Addendum No. 1

RE: Contract ID C202874

Brunswick County (BK-5129)

Replace Fender System Bridge #14 on NC-133 Over Atlantic Intracoastal Waterway
Between Southport and Oak Island

REVISIONS						SHEET NO.
NO.	BY:	DATE:	NO.	BY:	DATE:	S-1
1			3			TOTAL SHEETS 6
2			4

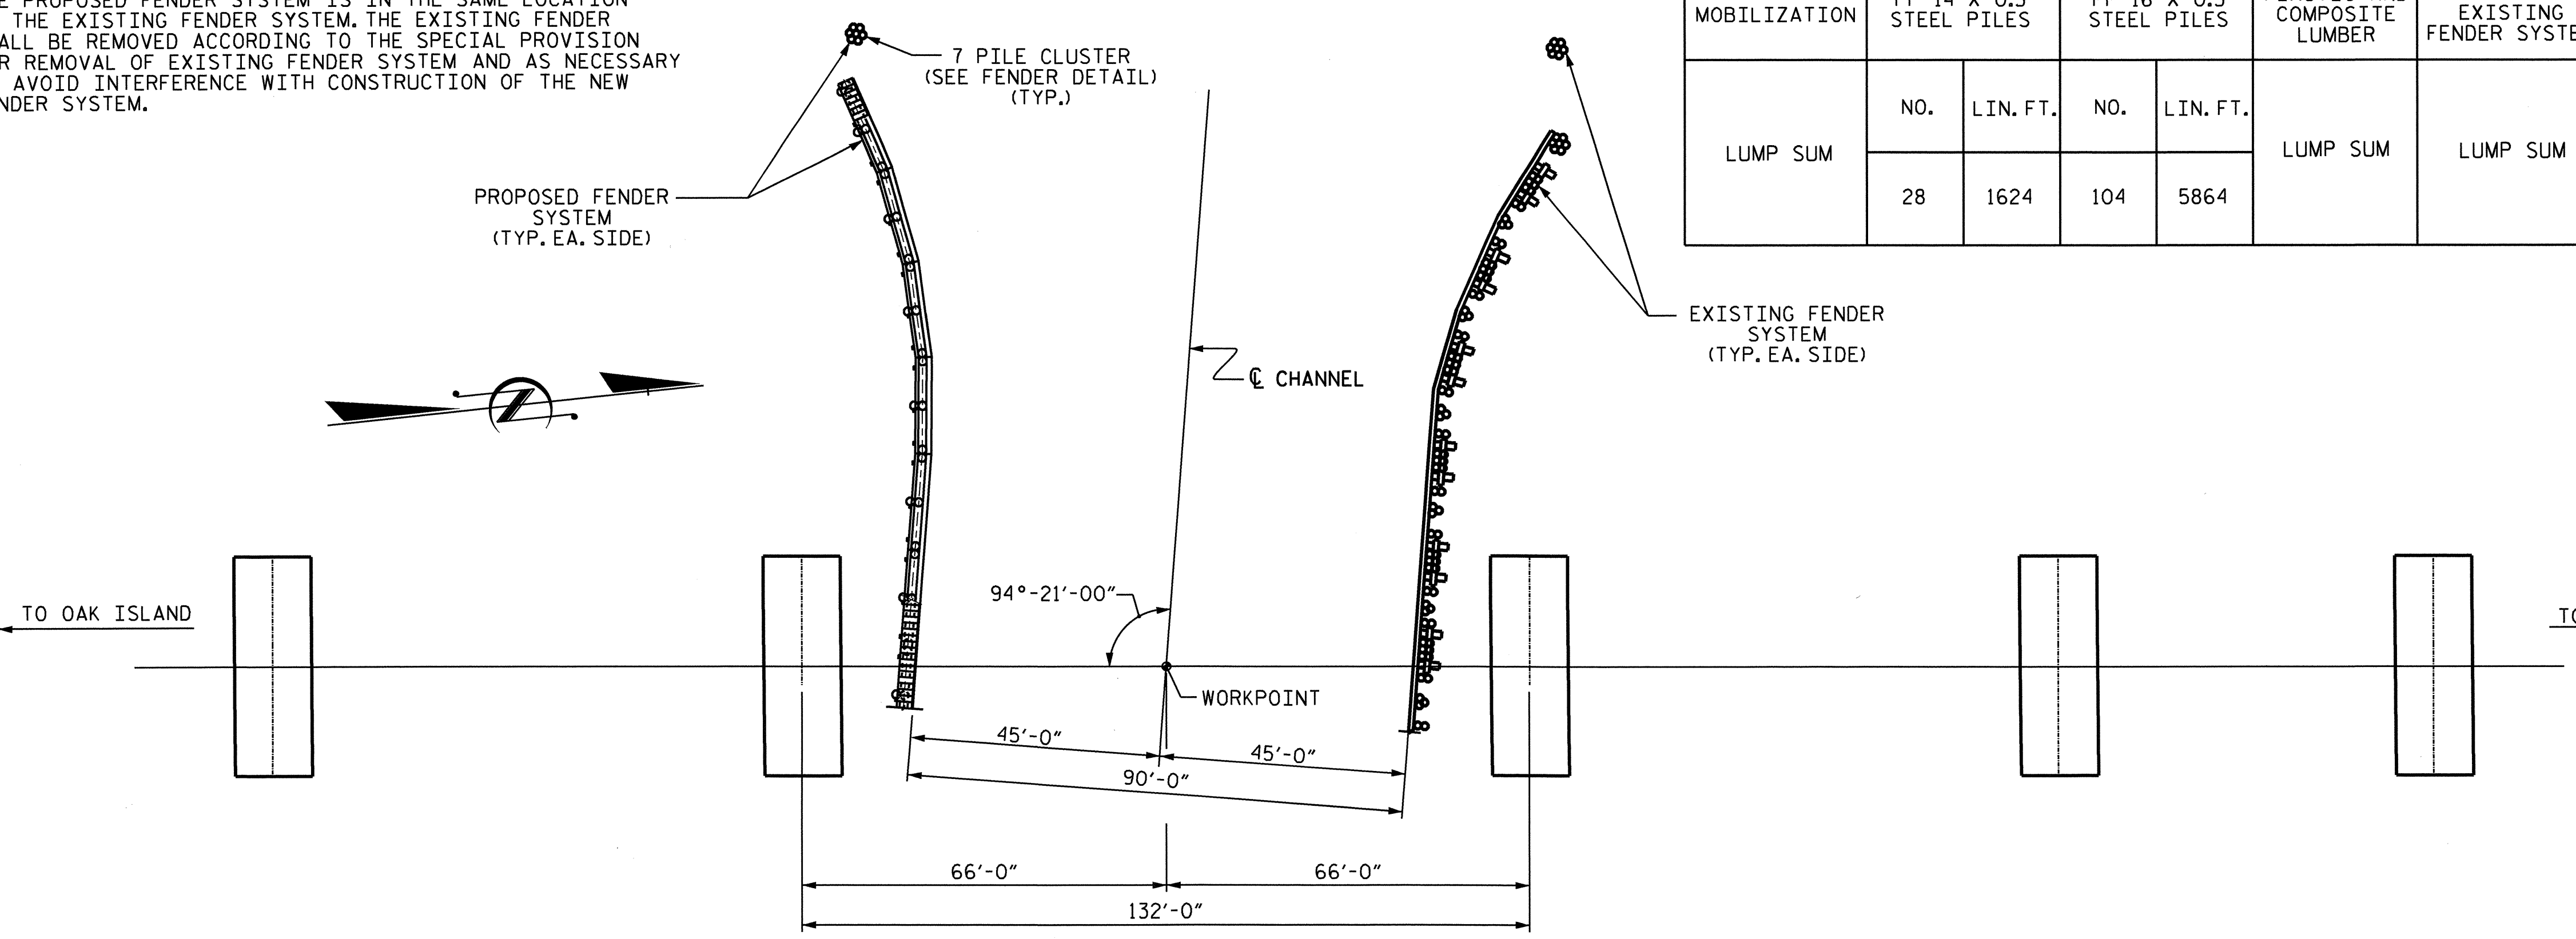
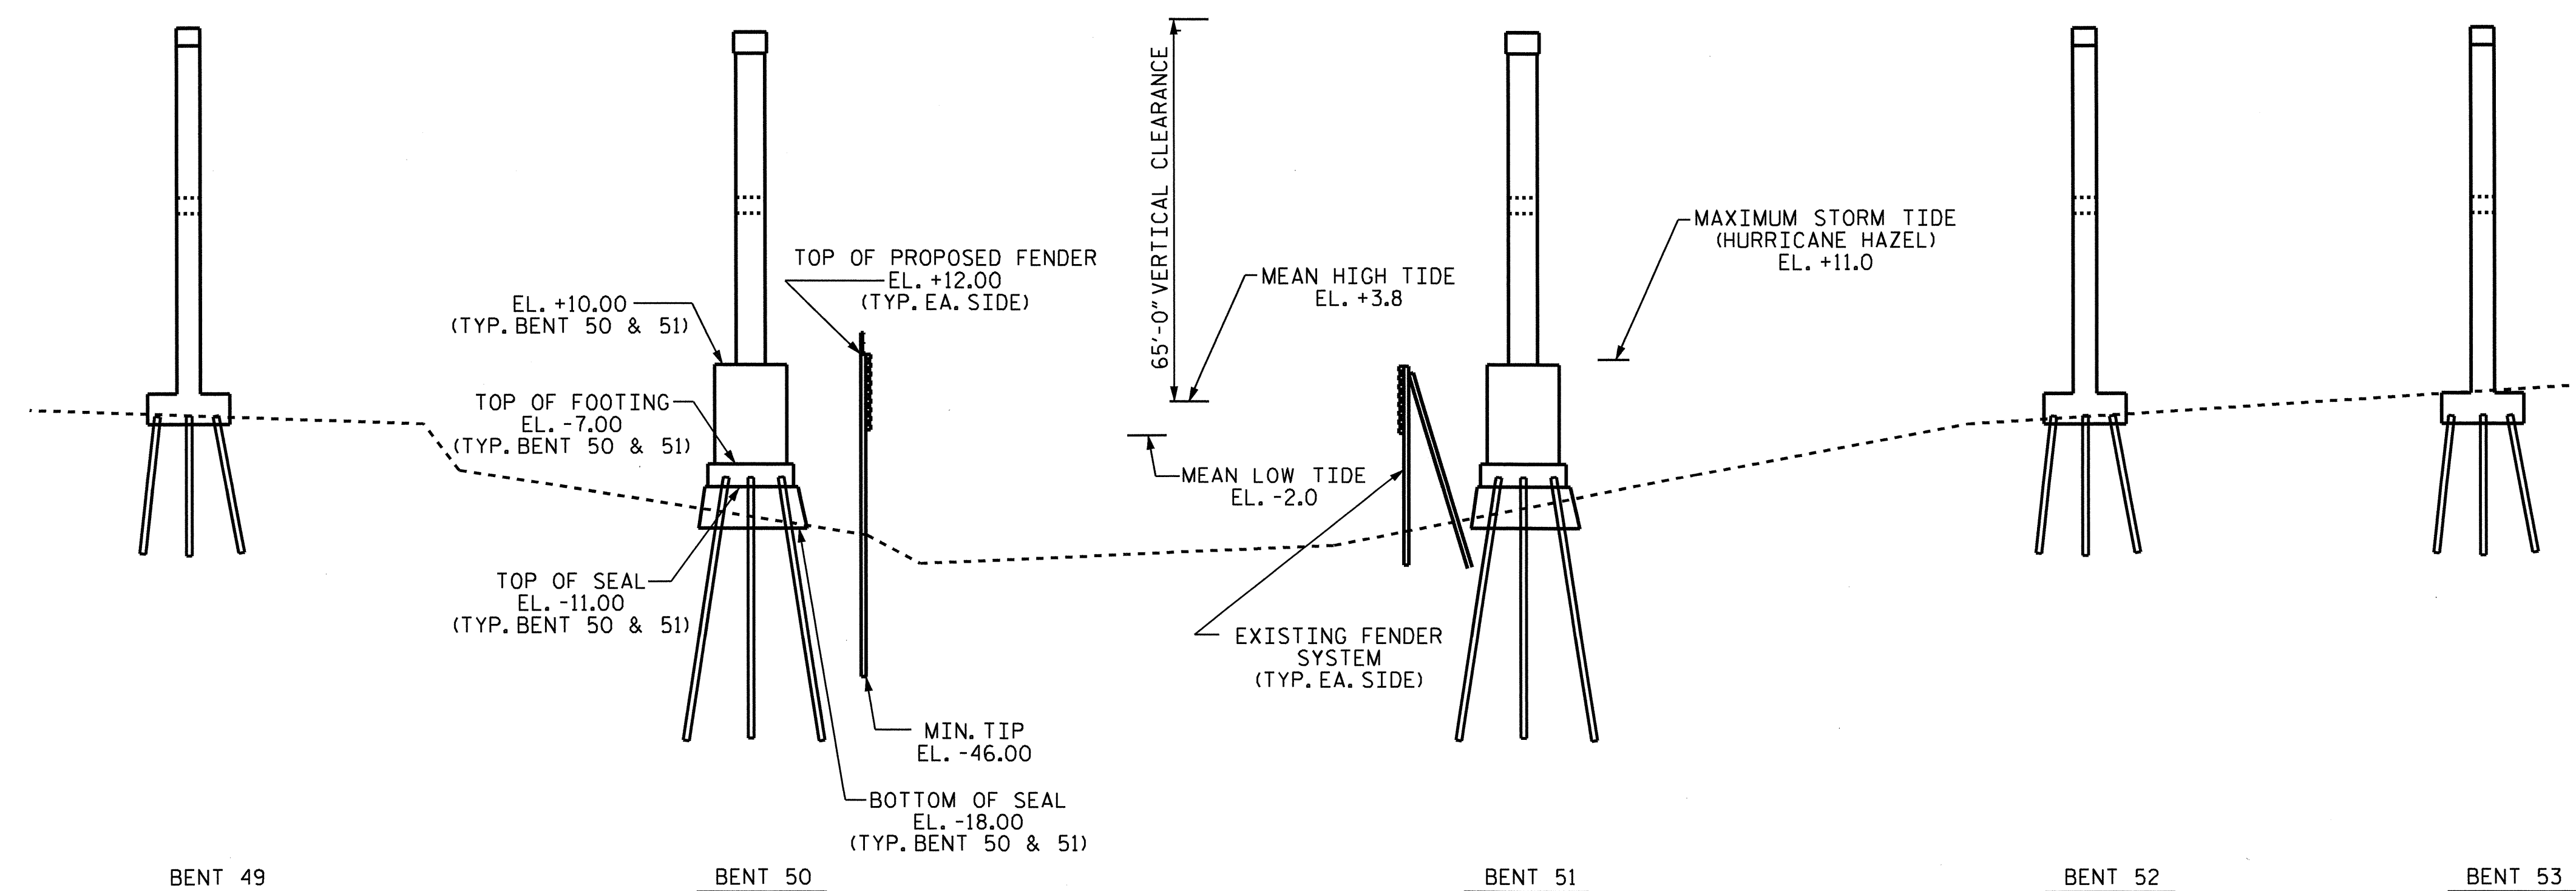
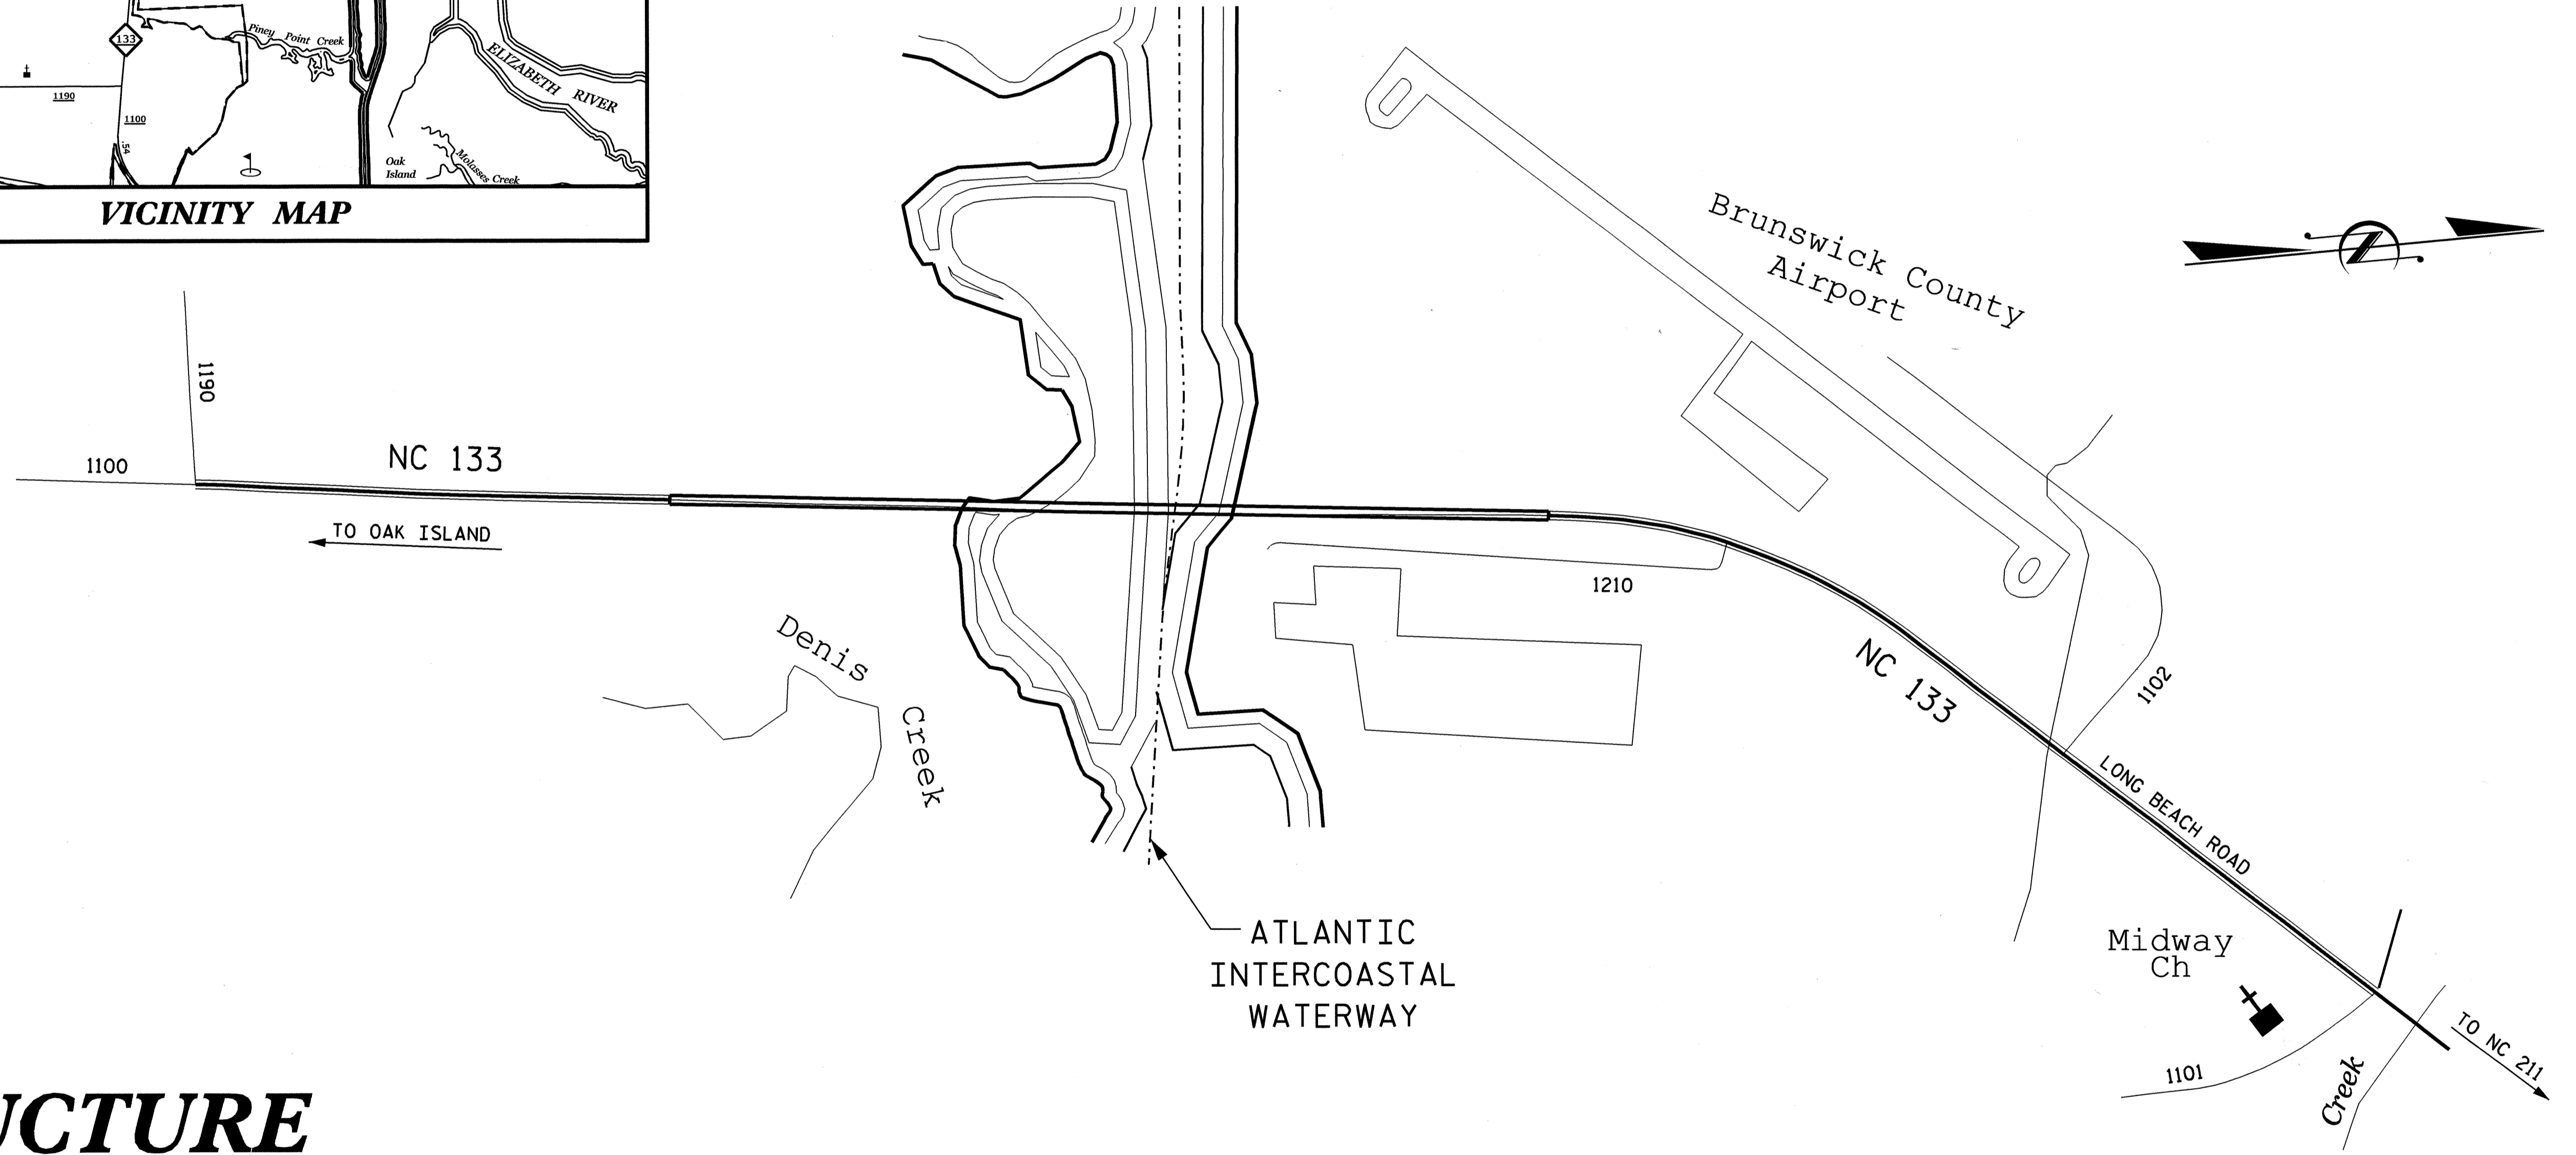
On Sheet S-1a note concerning cutting holes in piles has been added. Please void Sheet No. S-1 in your plans and staple the revised Sheet No. S-1 thereto.
